Application Number: 10DRB-70023, Minor - Preliminary/ Final Plat Approval

Location Description: ASPEN AVE BETWEEN MILL POND RD AND 12TH ST

DRB Comments

**RE: Lots 2-B-1 & 2-C-1, Lands of Forest Products, and
Tract H, A.T. & S.F. Industrial Area**

**PLAT OF  
 TRACTS 2-B-1-A & 2-C-1-A  
 LANDS OF FOREST PRODUCTS CO.  
 WITHIN PROJECTED SECTION 7, T. 10 N., R. 3 E., N.M.P.M.  
 TOWN OF ALBUQUERQUE GRANT  
 CITY OF ALBUQUERQUE  
 BERNALILLO COUNTY, NEW MEXICO  
 DECEMBER 2009  
 SHEET 1 OF 2**

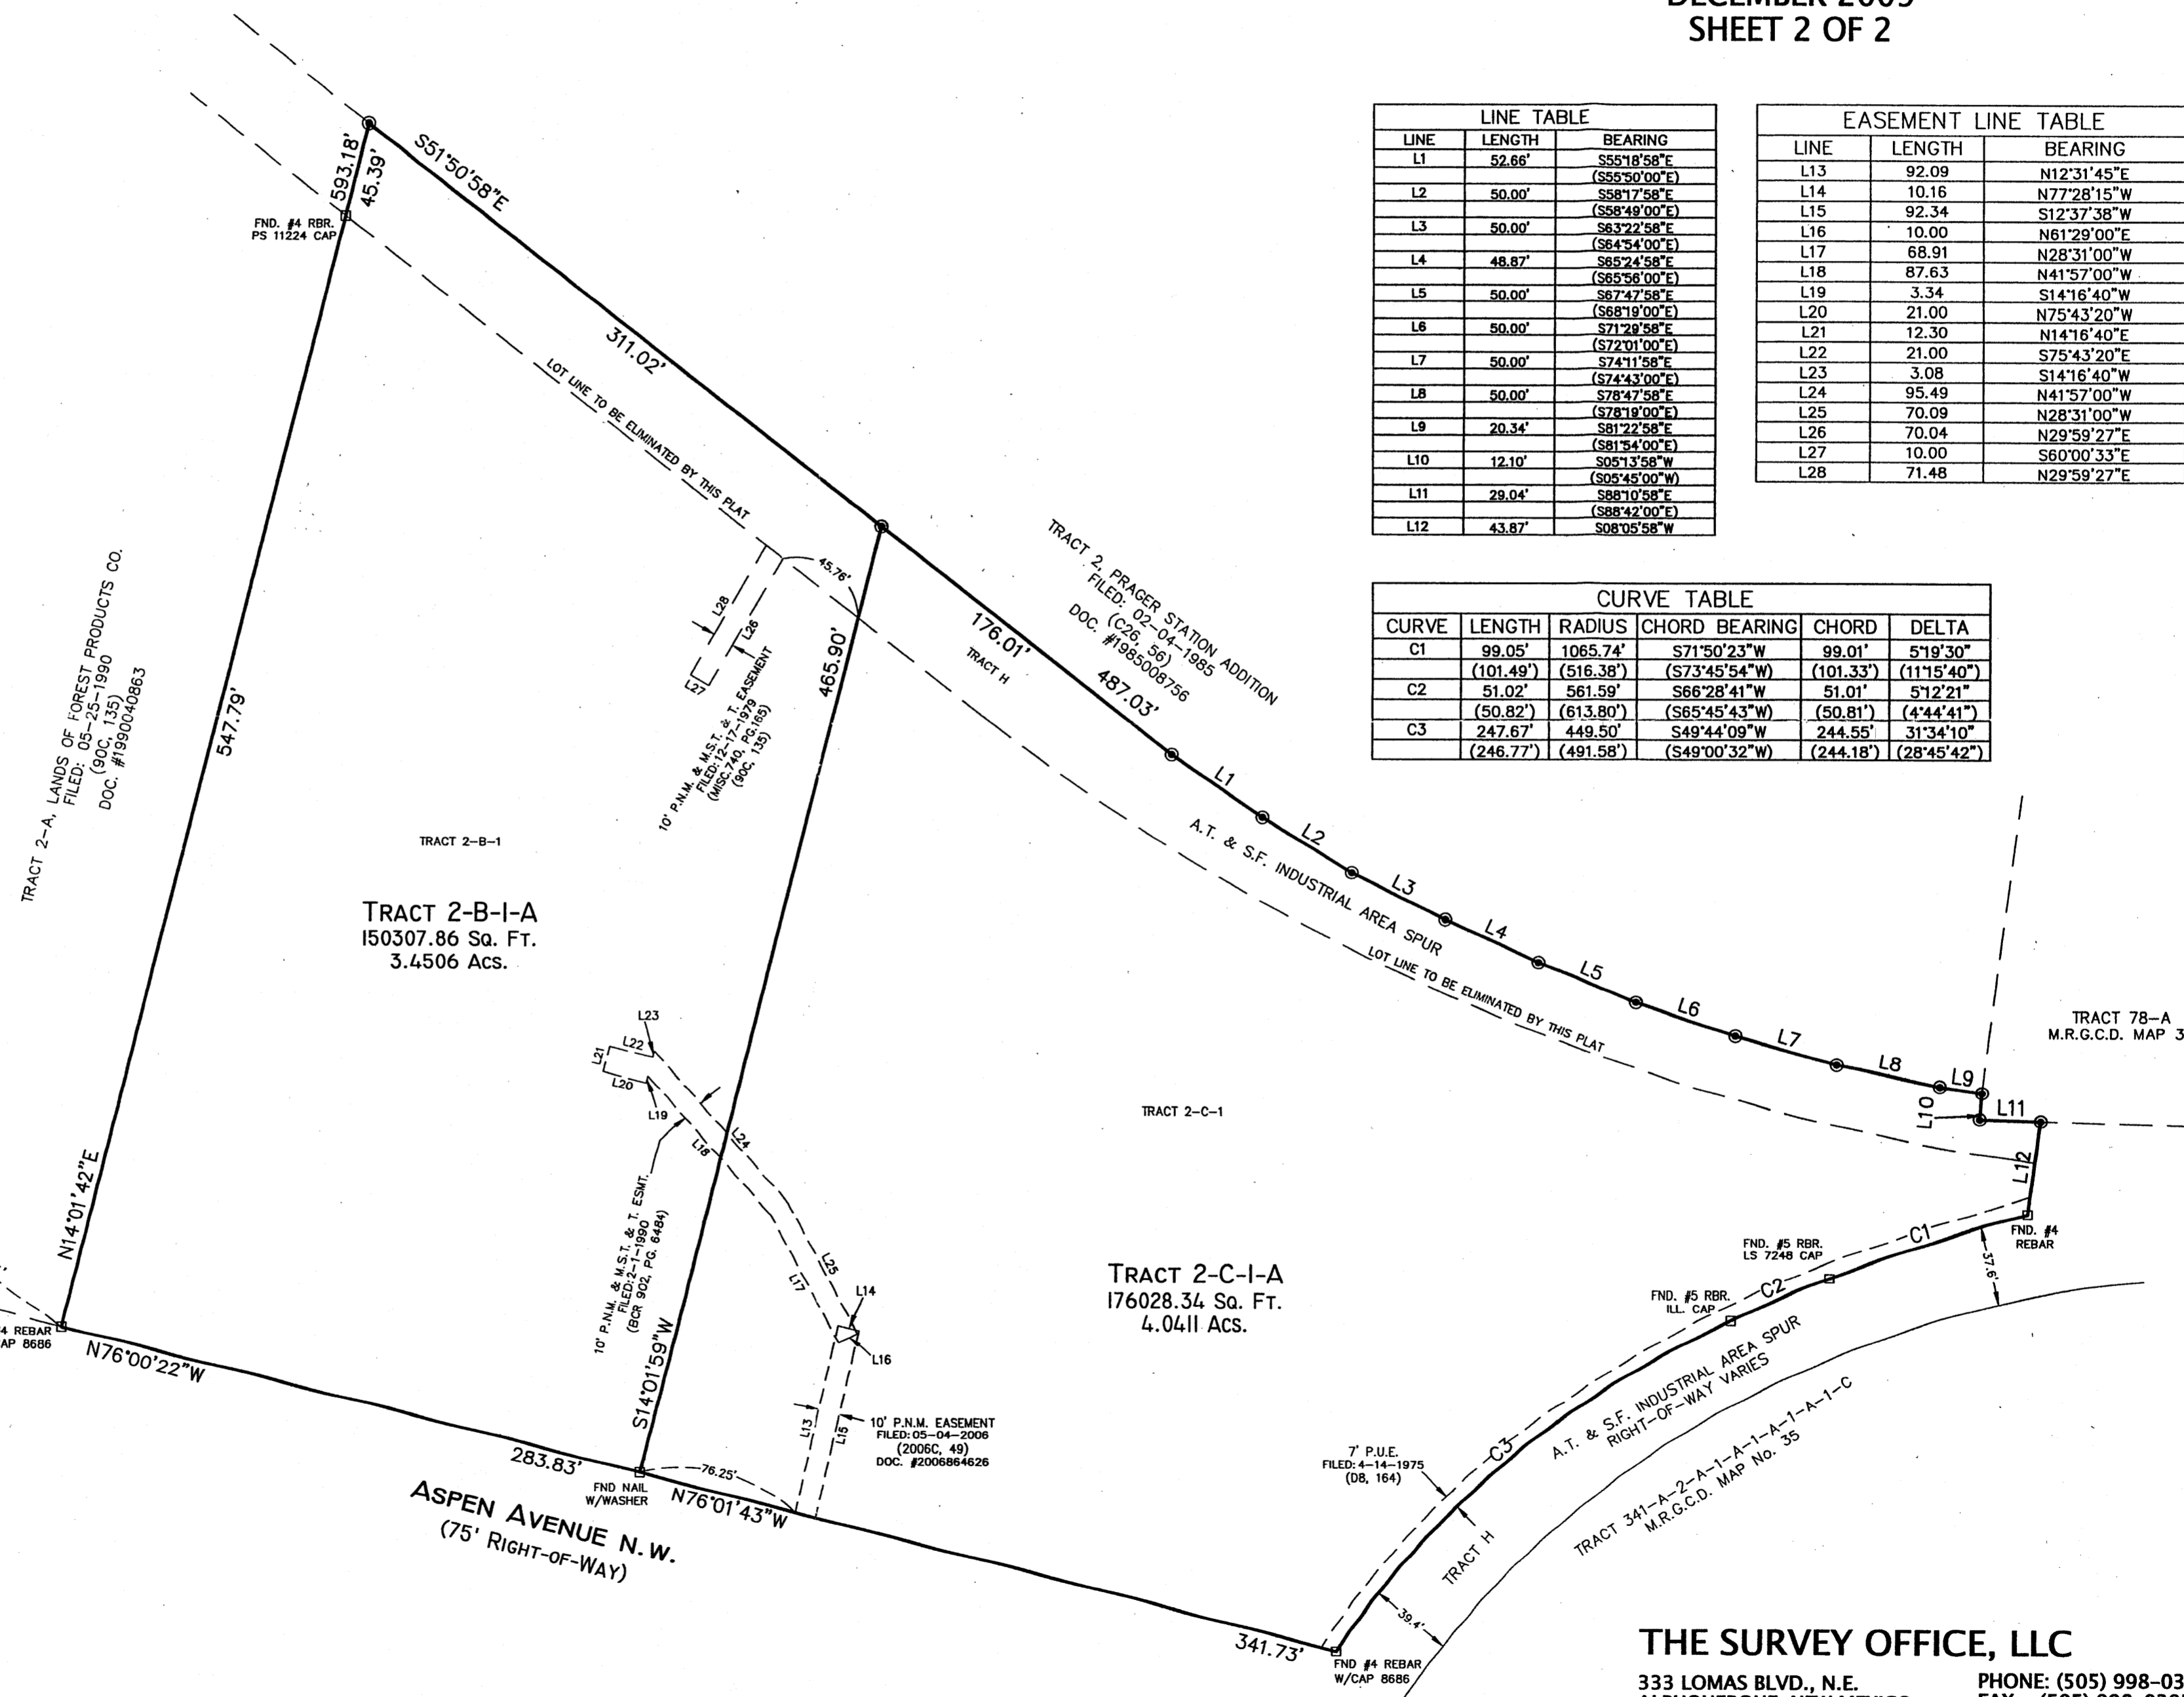
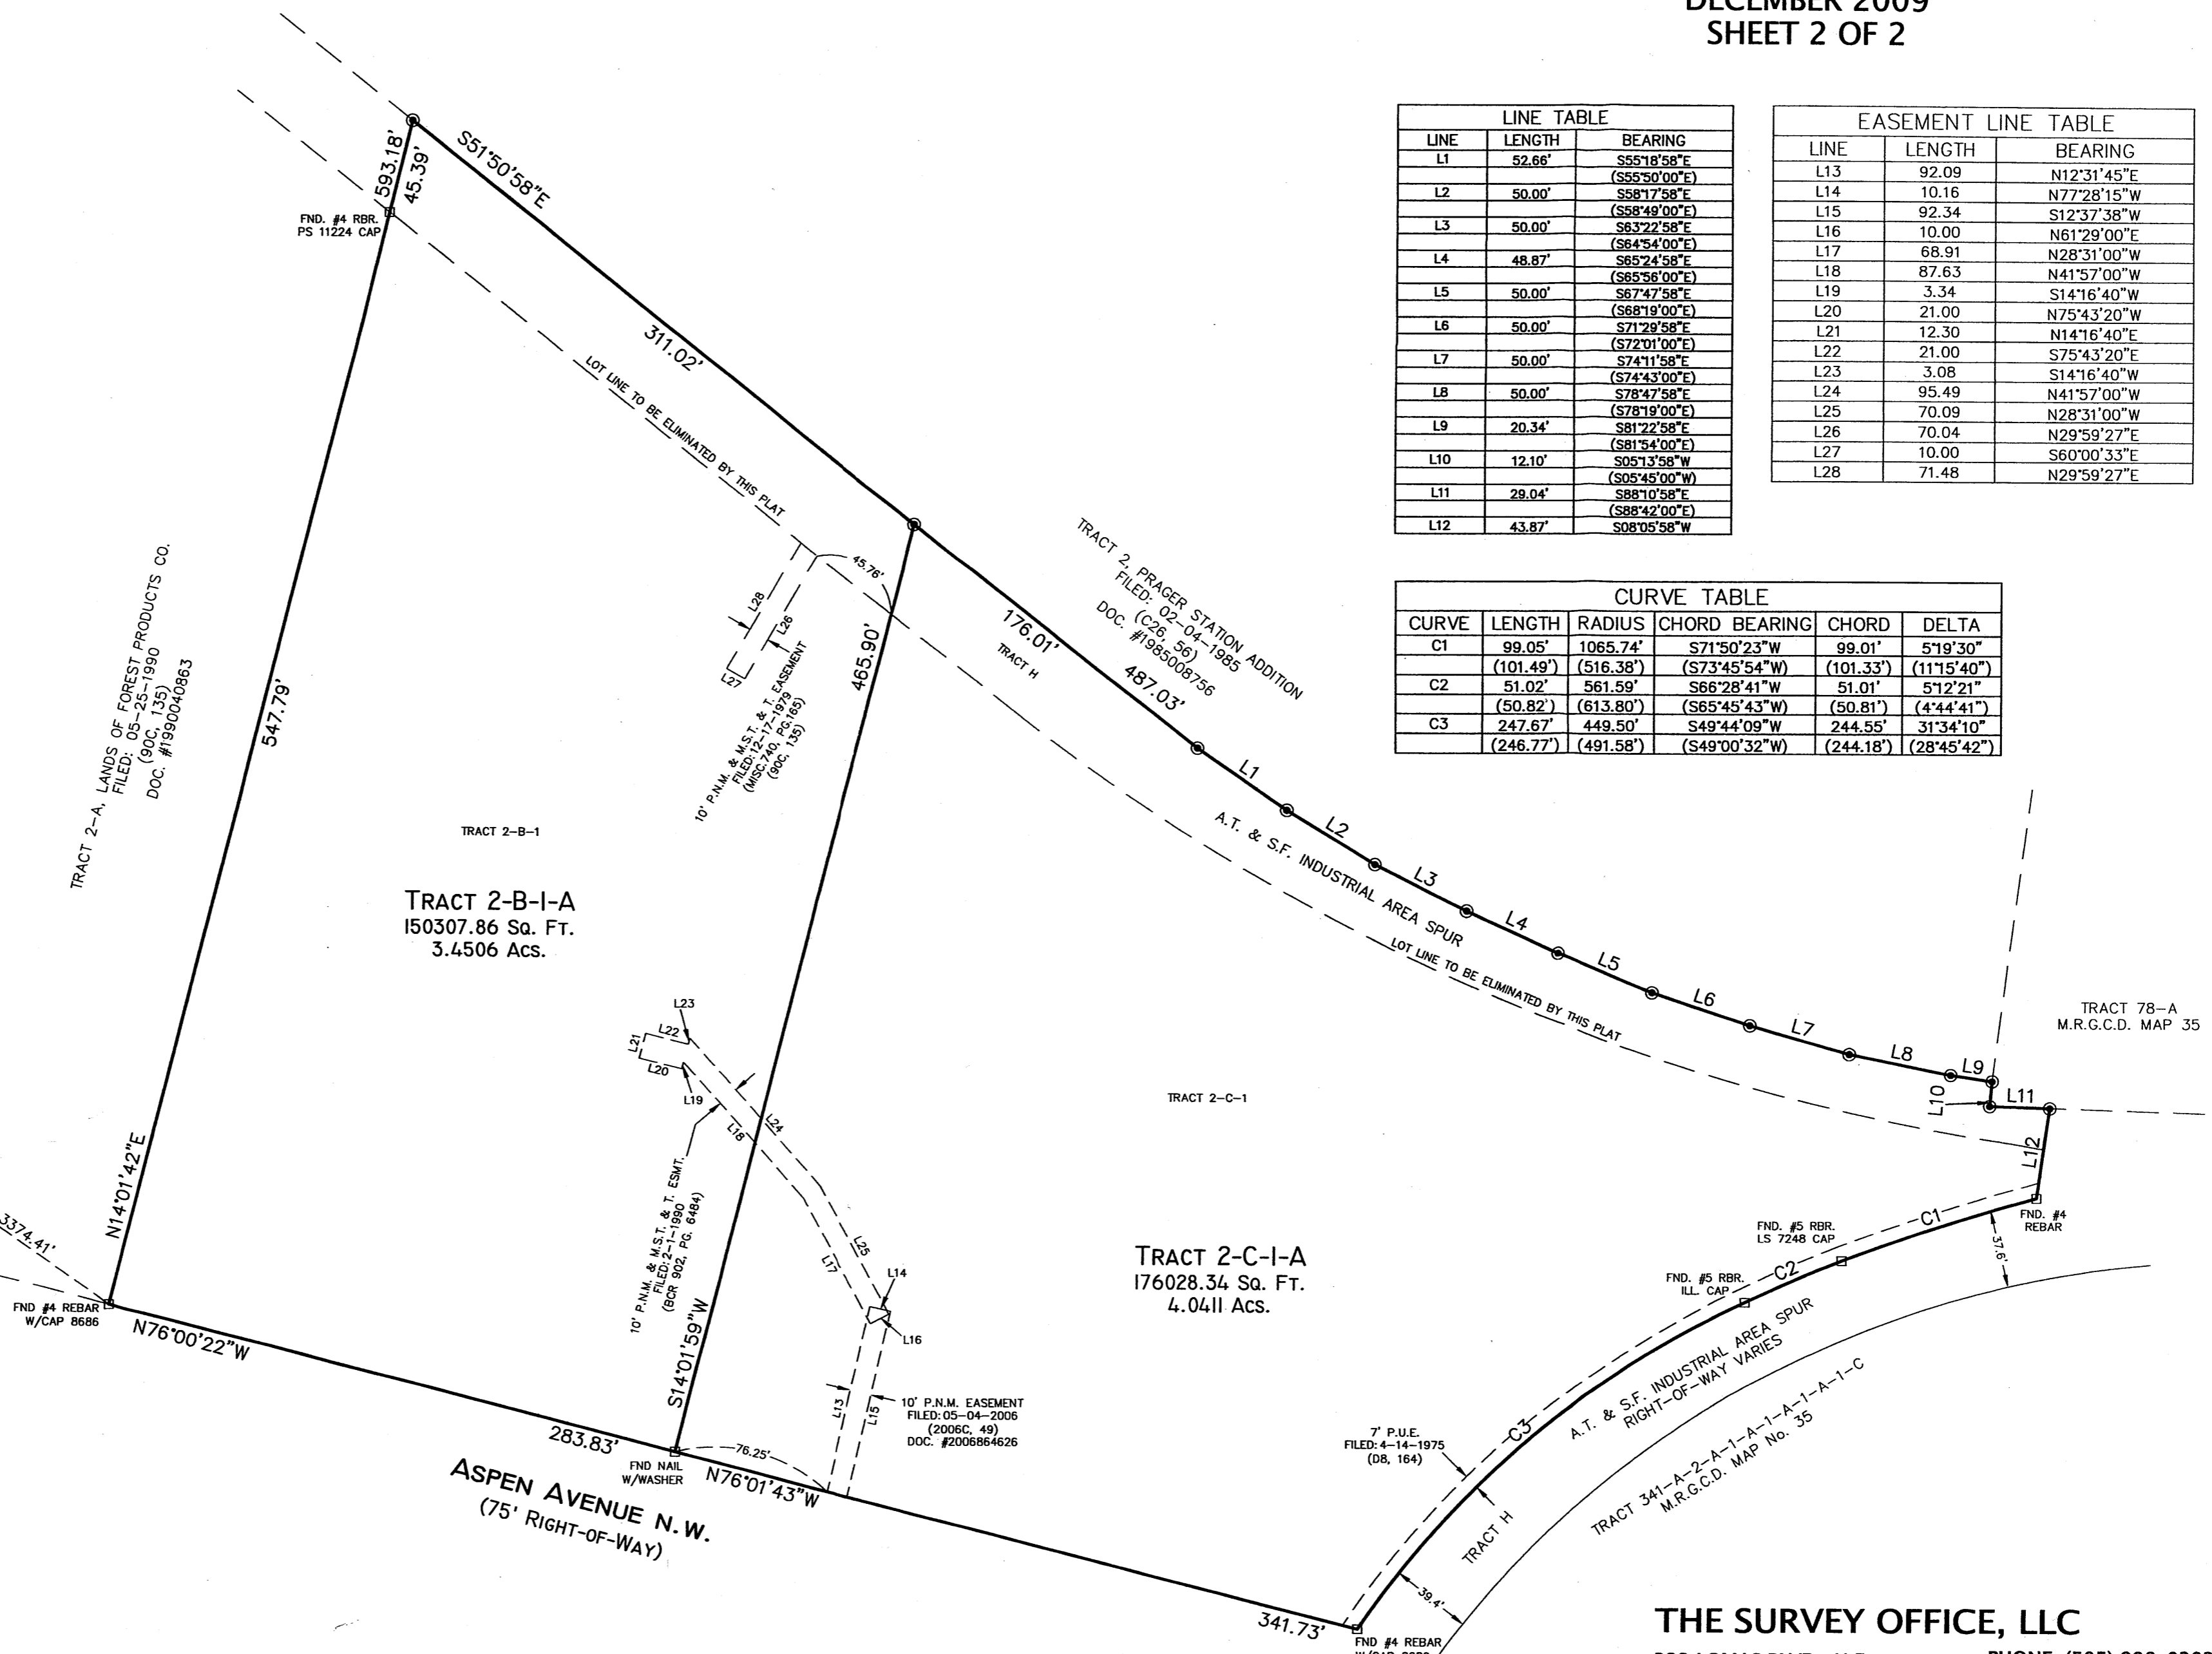
PLANNING (Last to sign): *Verify Court Order is sufficient for platting "portion of Tr. H"*

"Portions of" Tract H need to be documented prior to the current Subdivision Ordinance (1973) or else the entire tract needs to be part of the plat, with the remainder to be designated as Tract H-1.
